Planning Application Reference No.: 3/2024/0465

Address of Development: Barnacre Road Primary School, Barnacre Road, Longridge, PR32PD

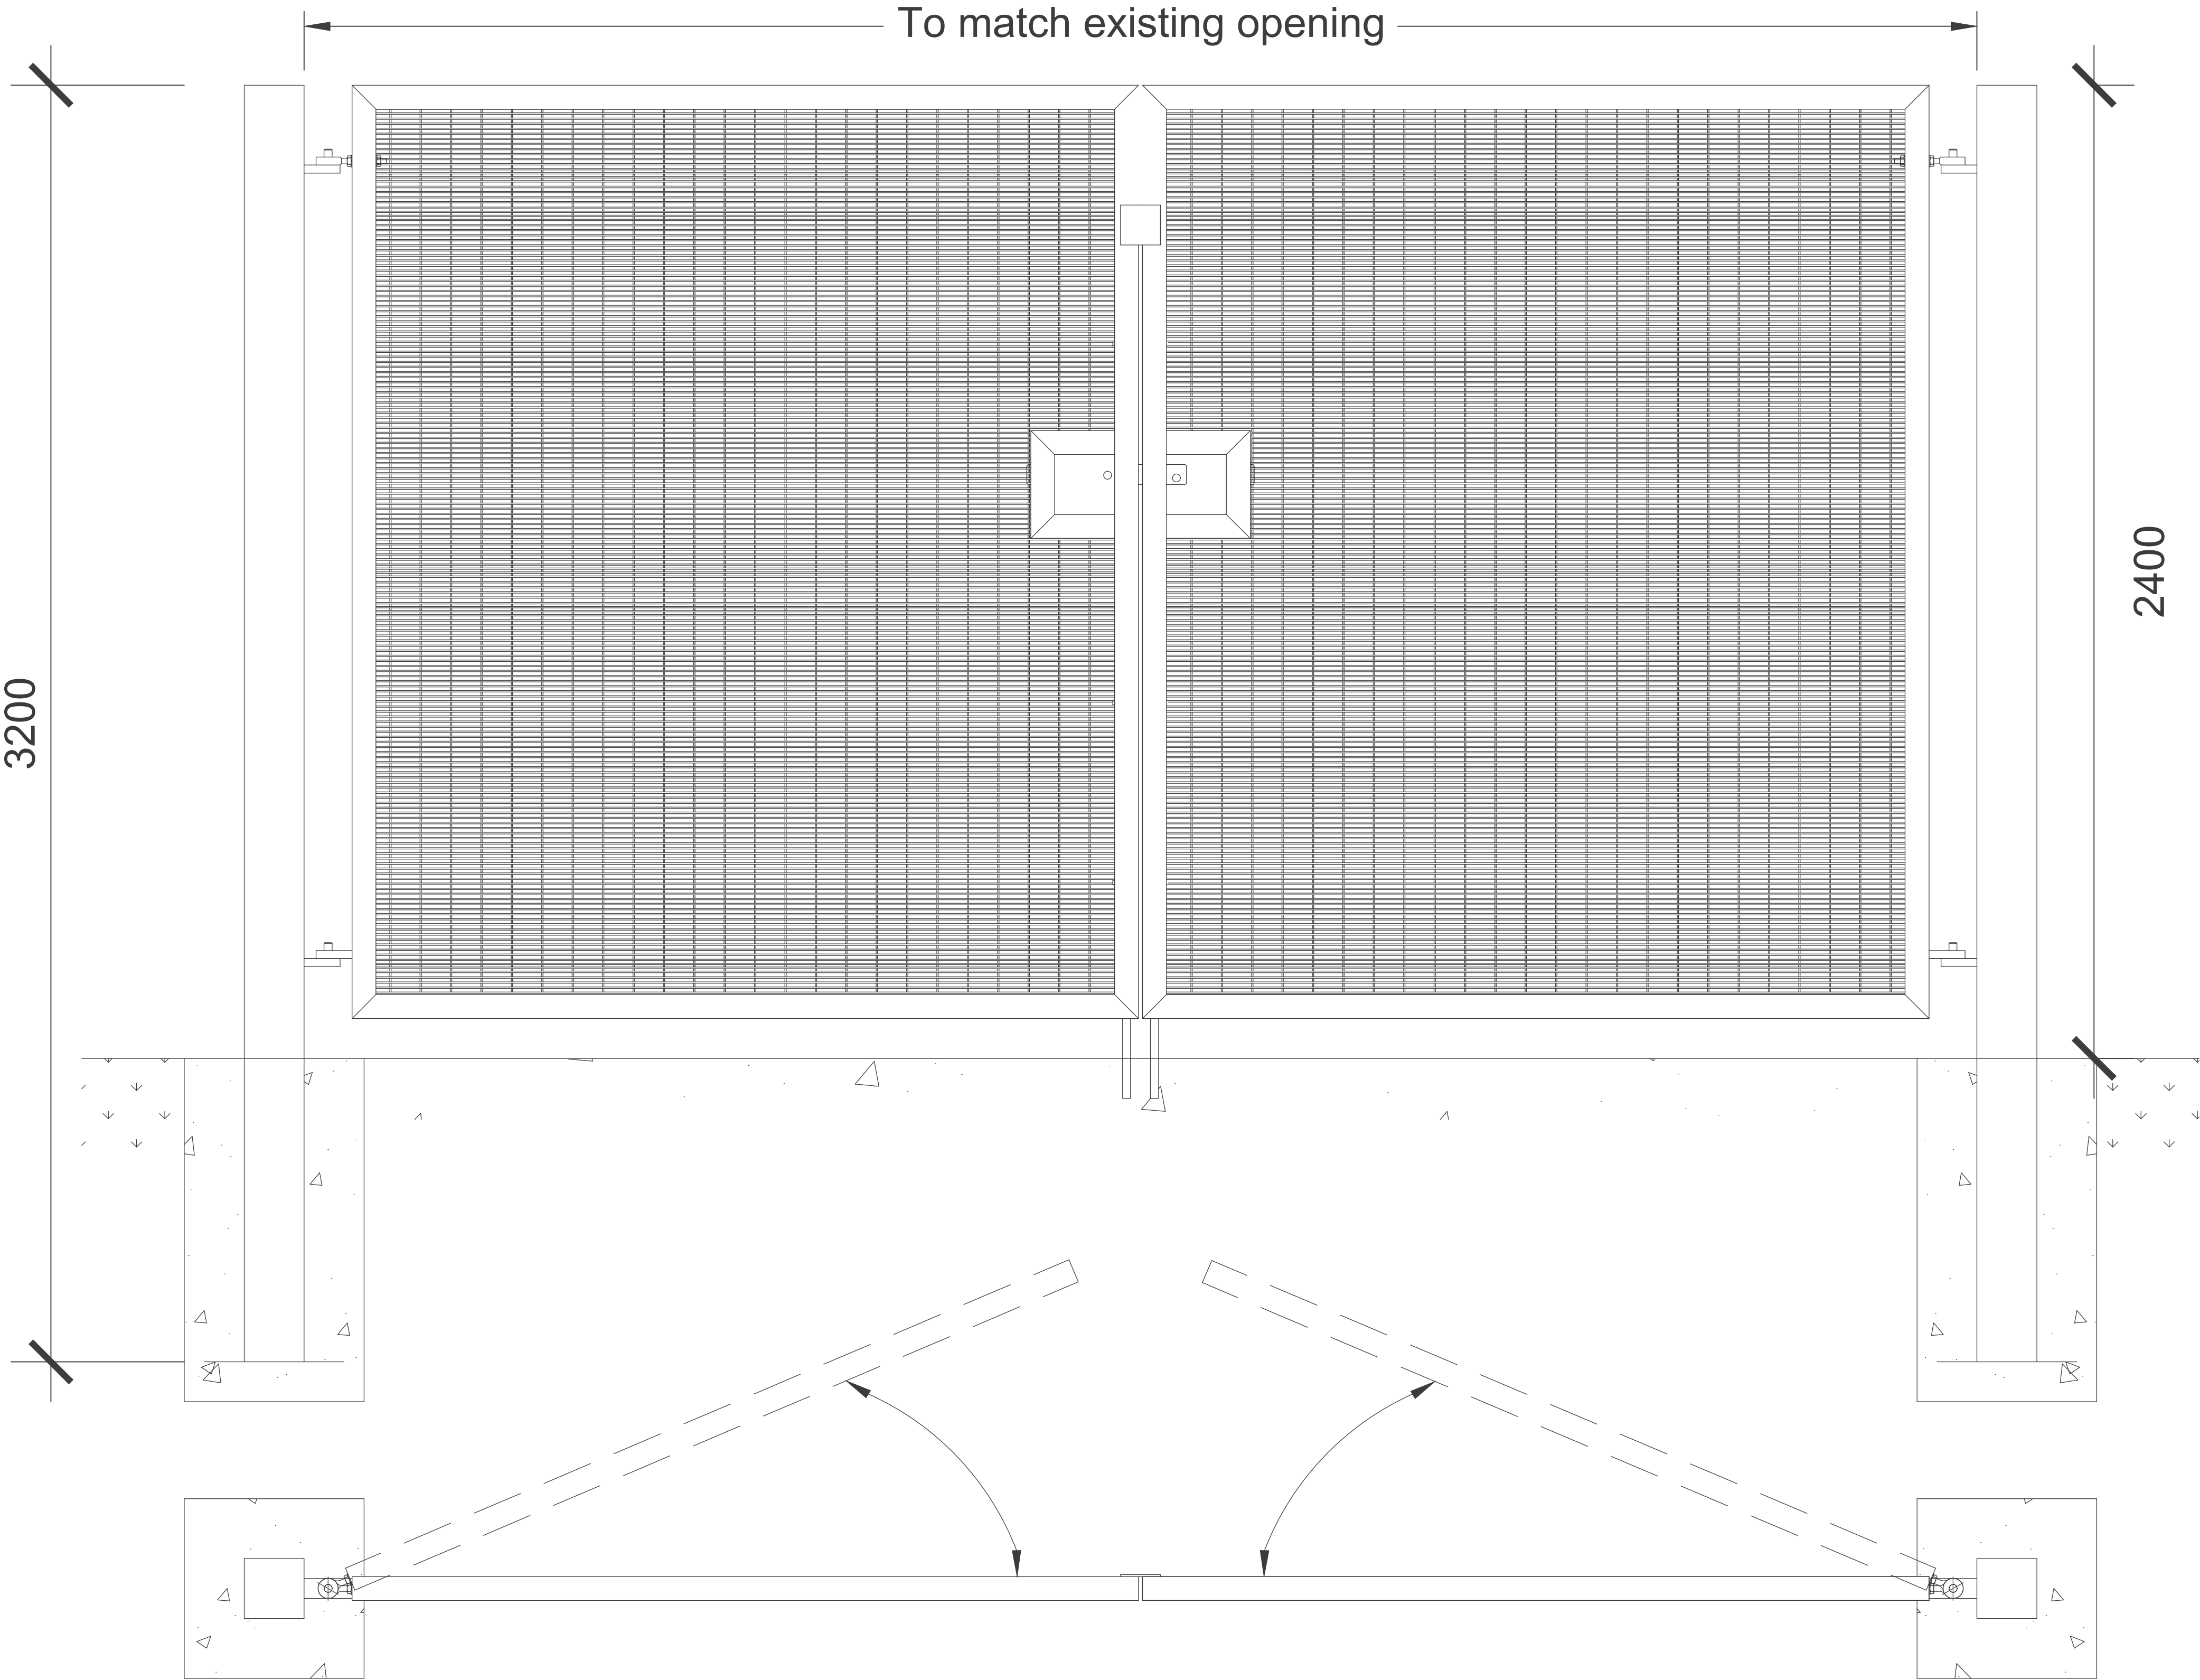
- 5. The proposed electric gate G4 may also cause a noise Nuisance.
- 6. May I ask that you consider this application carefully and arrange to meet the affected residents on site and view the effect on site.

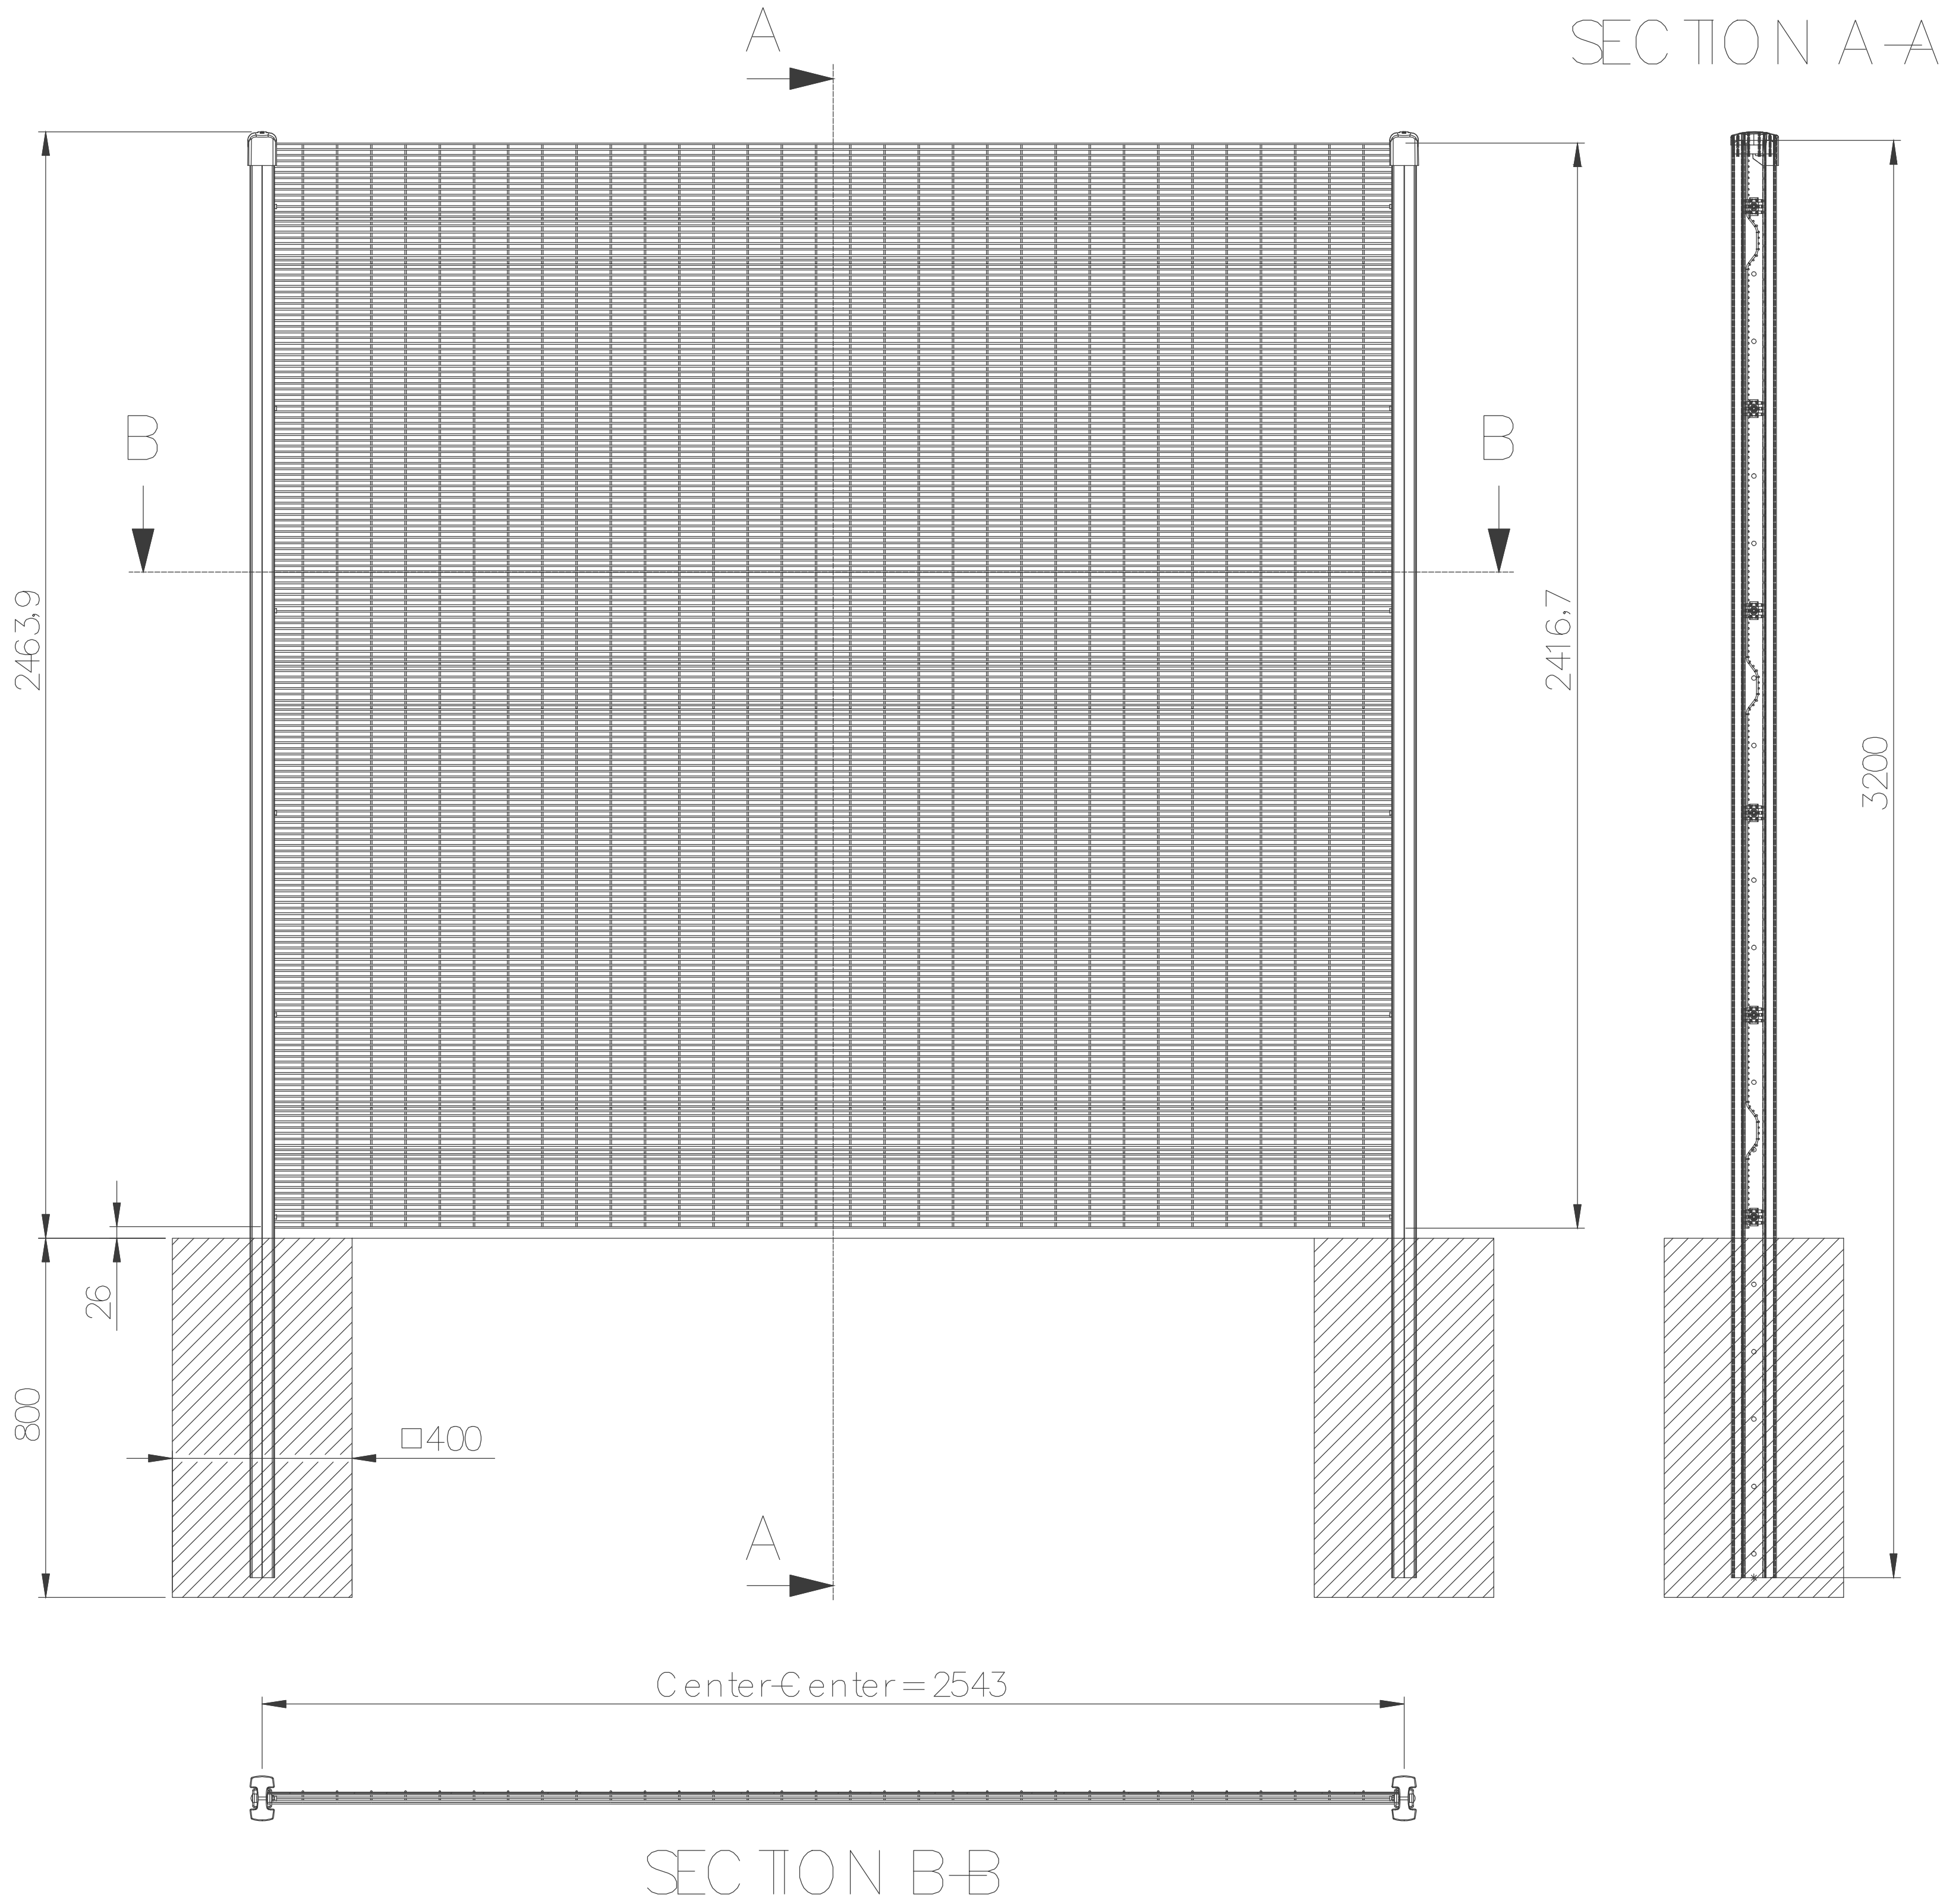
I have received a letter re the planning application from Barnacre road school, I have reviewed the plans on line, i feel the height of the fence at 2400mm is to high could it be reduced to 1800mm? which would be more acceptable for the rear of the houses along Inglewhite road, as the proposed new fence line is right next to the existing beech fences, which in place is planted on a higher level ground level.

I am extremely unhappy as are my neighbours with the fence height of 2.4 metres.

I would like to request that the height of the fence be reduced to 1.8 m. I have researched statutory heights for school fencing and 1.8m comes within the statutory guidelines.

- 2. As described the fencing wires vertical and horizontal are very close together and at the height of 2.4m will visually reduce any views currently have considerably ,giving the impression of a steel prison!
